Administrative Authorization Decision

Application #: 2013-168

Name: 498 sq ft of additional pavement

Address: 504 RIVERSIDE ST

Job No.: 237      Sheet No.:  
Date: August 2013  
Scale: 1" = 10'  
Drawn: AMC  
Checked: VFM  
**C1.0**

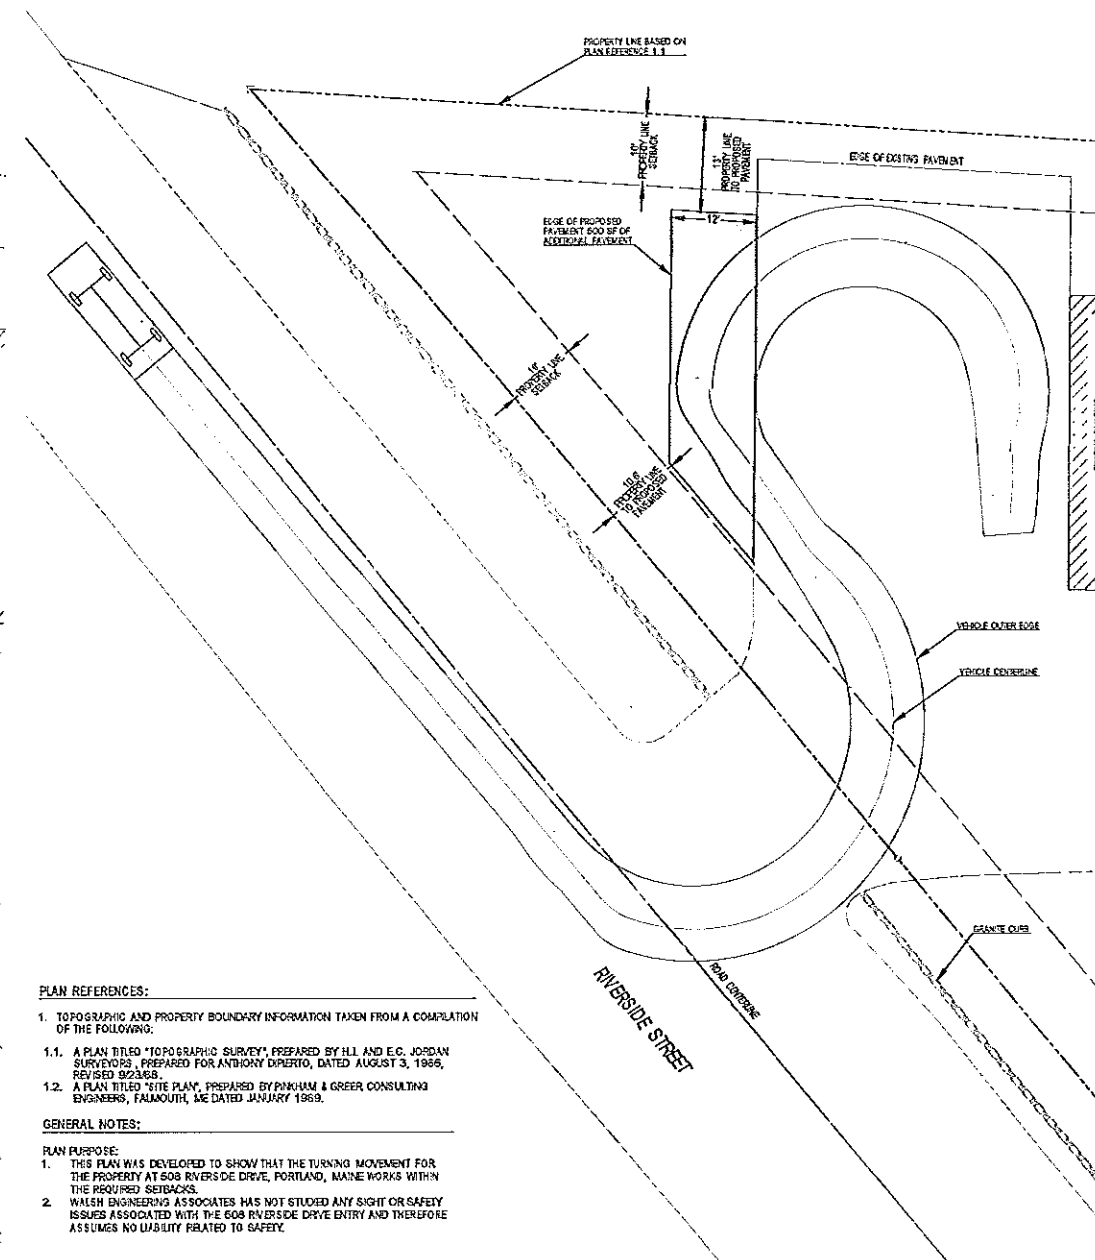
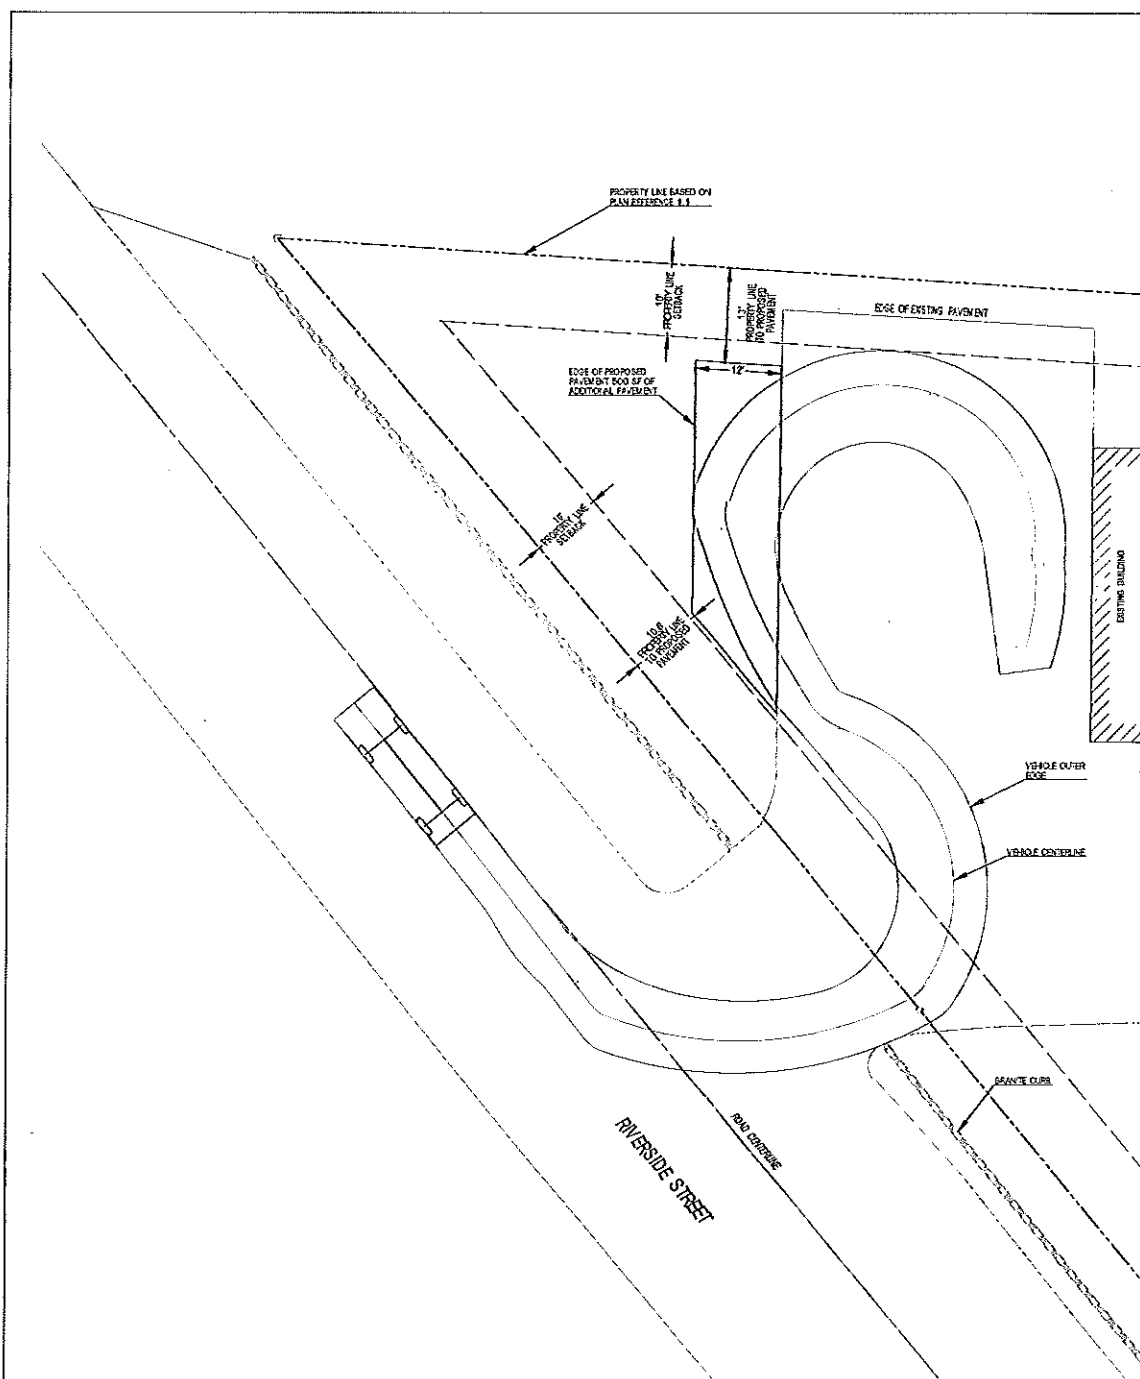
c) Is the footprint increase less than 500 sq. ft.?	Yes	Yes- Bill Walsh, PE confirmed increase in impervious surface is 500 sf
d) Are there any new curb cuts, driveways or parking areas?	No	No, - circulation pattern revised to serve drop off window

h) Is there an increase in traffic?	No	Tom Errico, Traffic Engineer, looked at the plans and turning template. He approved the plan
i) Are there any known stormwater problems?	No	No

- 1) On August 15, 2013, Tom Errico, Consulting Traffic Engineer, found the plans for the traffic circulation shown on-site for the plans prepared by Bill Walsh (dated C.1.0, August 2013) to be acceptable.
- 2) The request for an administrative authorization for the 500 square foot expansion of pavement, as shown on the site plan, is approved with two conditions:
 - 1) The pavement shall be installed as shown on the site plan prepared by Bill Walsh (August 2013, C.1.0), which confirms the setbacks from property lines and area of pavement; and
 - 2) Obtain all required permits from the Inspection Division.
